CITY OF ALBUQUERQUE

December 2, 2024

RE: 2611 Rio Grande Blvd. NW
Conceptual Grading & Drainage Plan
Engineer's Stamp Date: 11/13/2024
Hydrology File: G12D045

CG-101

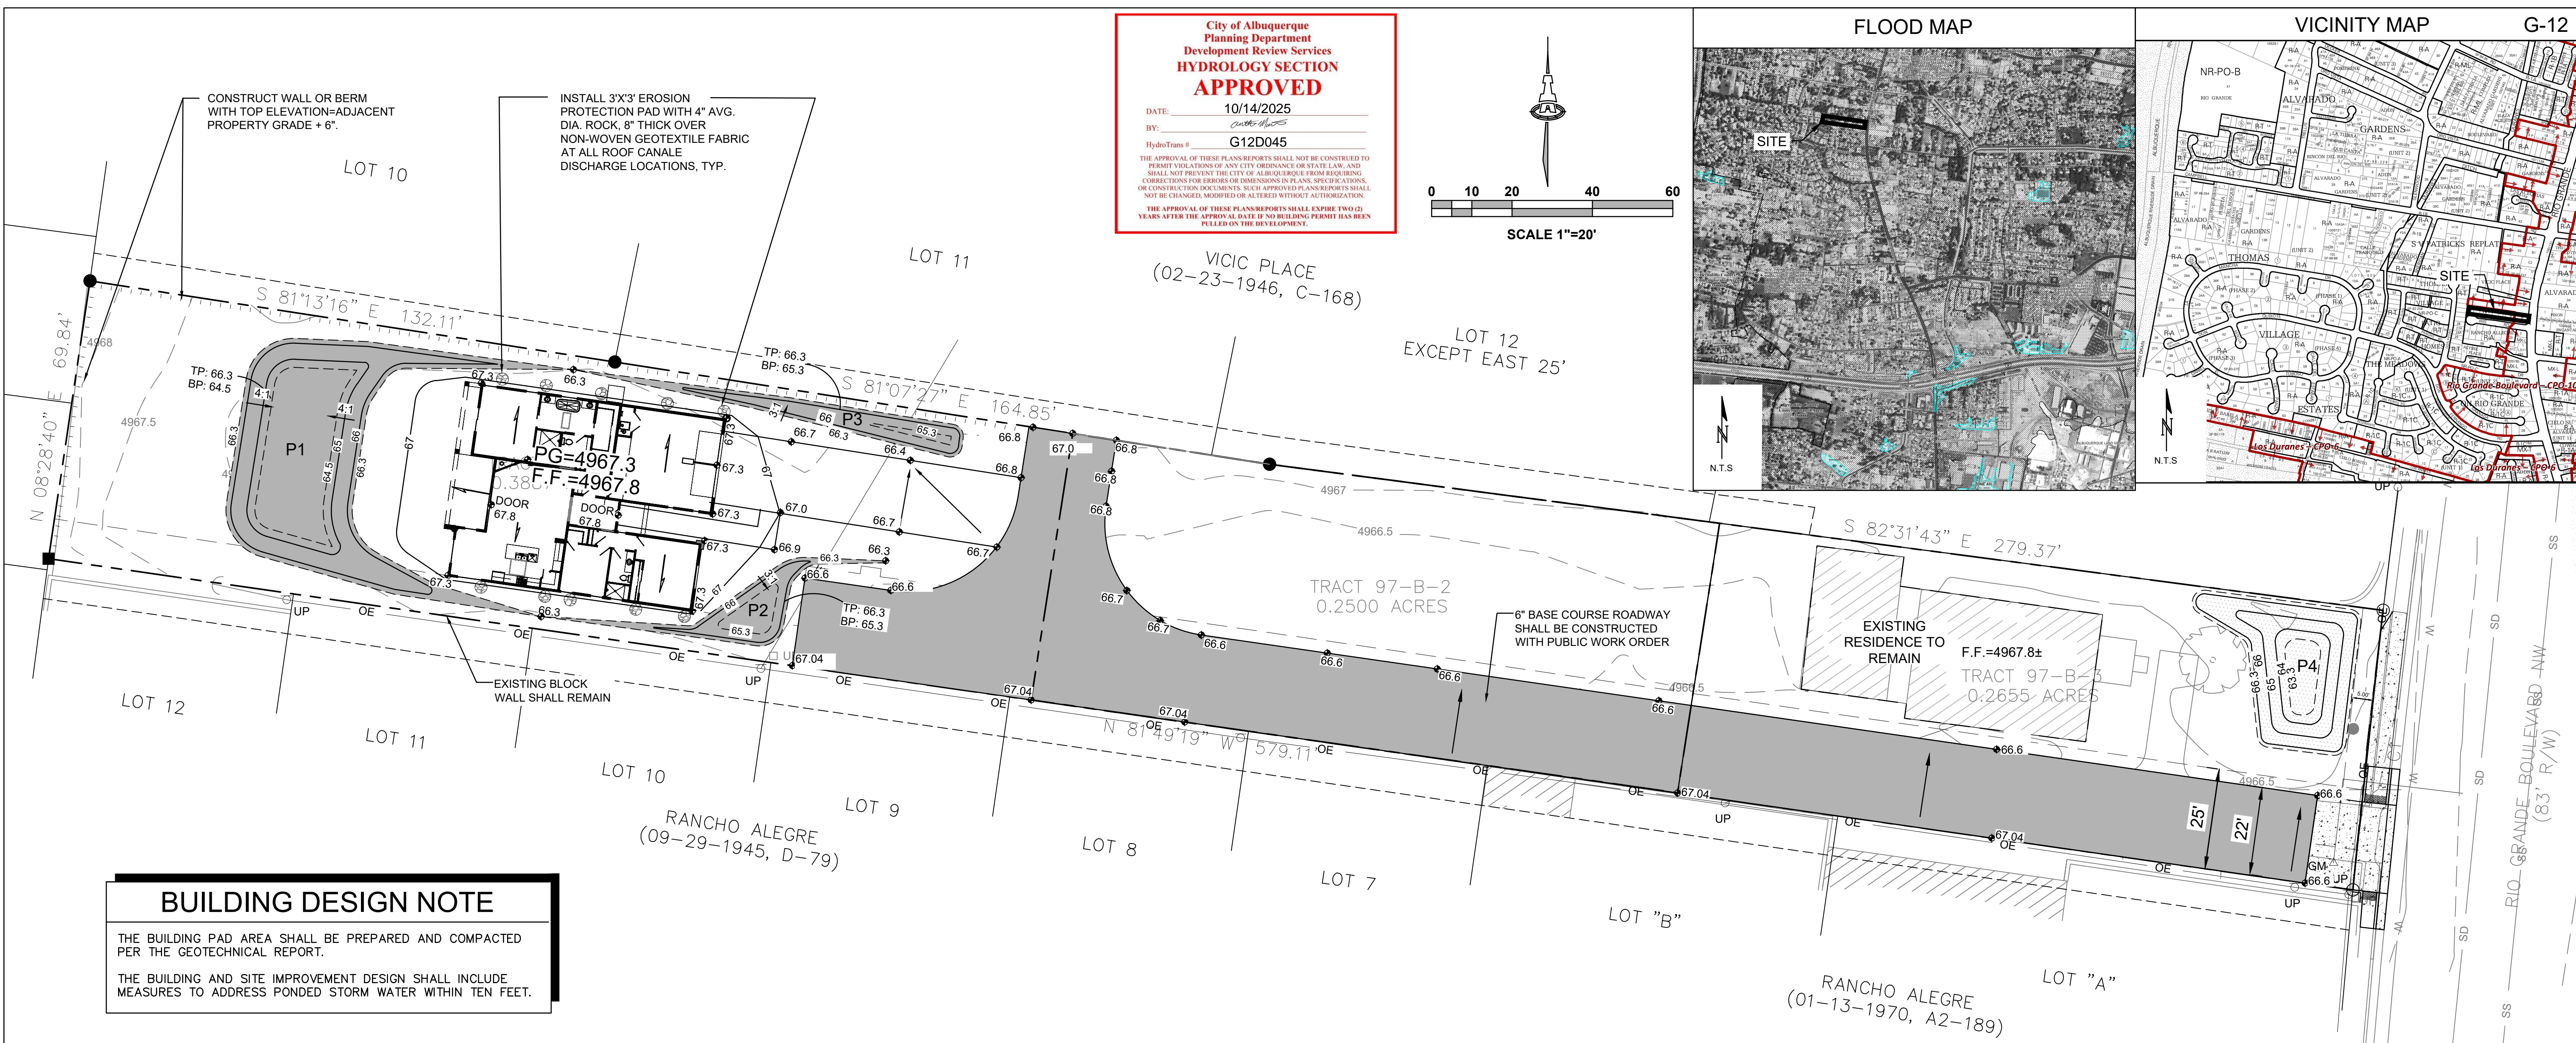
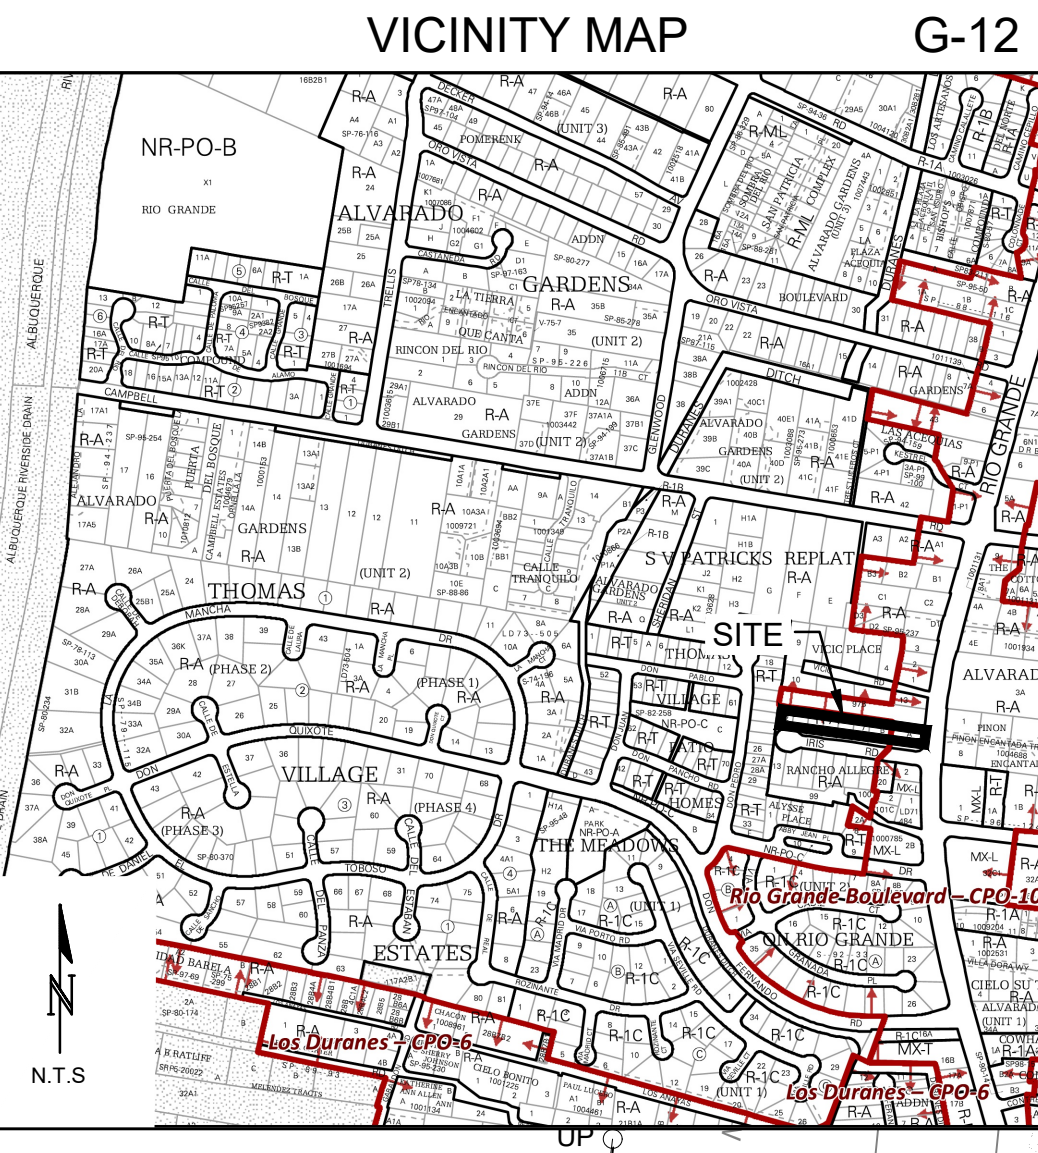
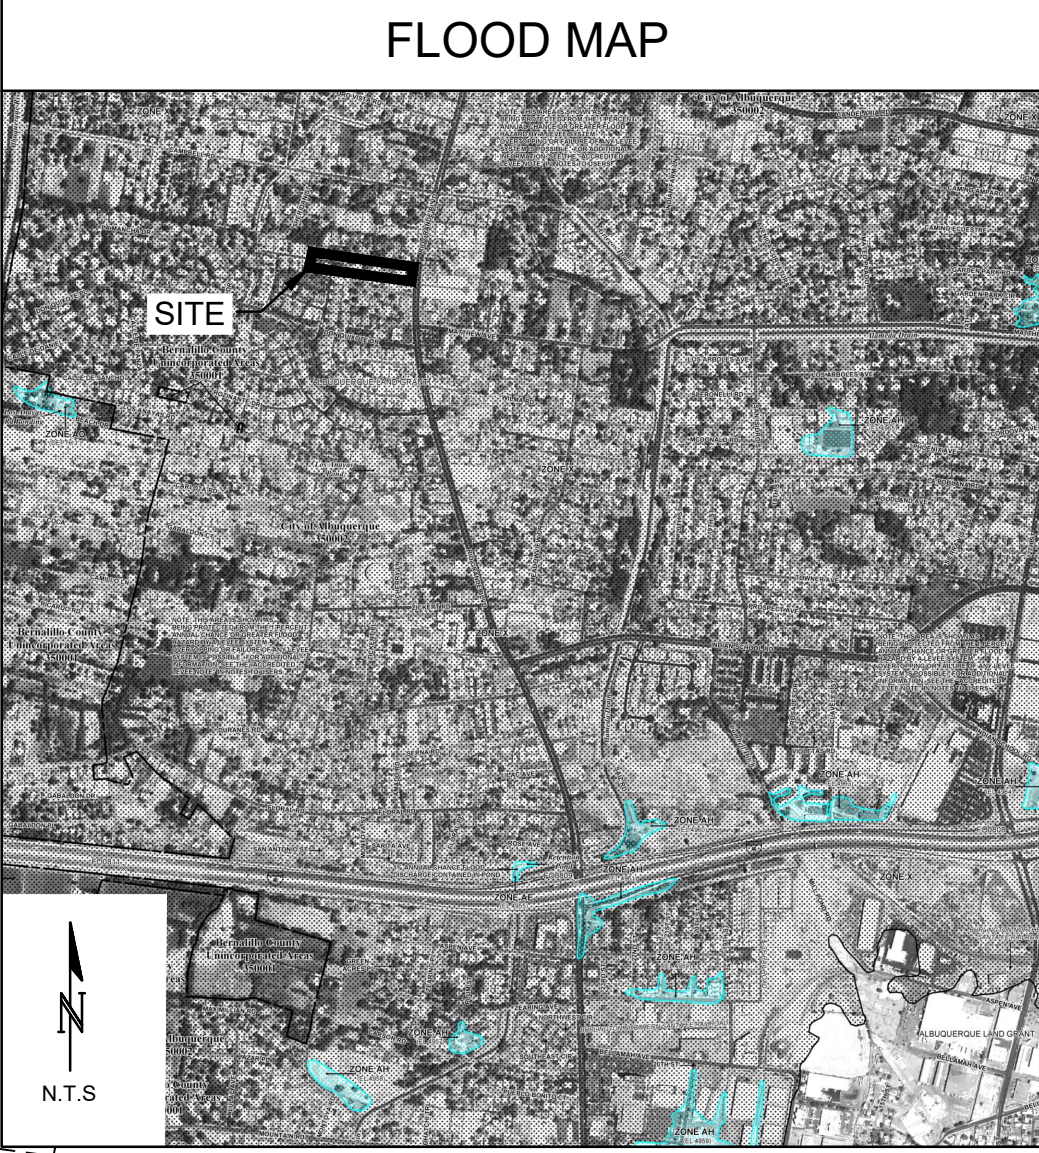
1. Identify the pond location for Lot 97-B-3, onsite generated storm water should remain onsite and not flow into Rio Grande Blvd.
2. Since this site is in the Valley region, please follow Article 6-5 Valley Drainage Criteria of the DPM. The following conditions must be applied to the site:

- Pad elevation shall be a minimum of one (1) foot above the 100-year 10-day stormwater surface elevation.
 - The flow between the front yard and back yard cannot be obstructed. The stormwater must be allowed to equalize to the same level between the front yard and back yard.

- A permanent perimeter wall or barrier around the development is required to contain the 100-year 24-hour storm developed runoff.
 - The high point of the street should be four inches above the 100-year 10-day stormwater surface elevation.
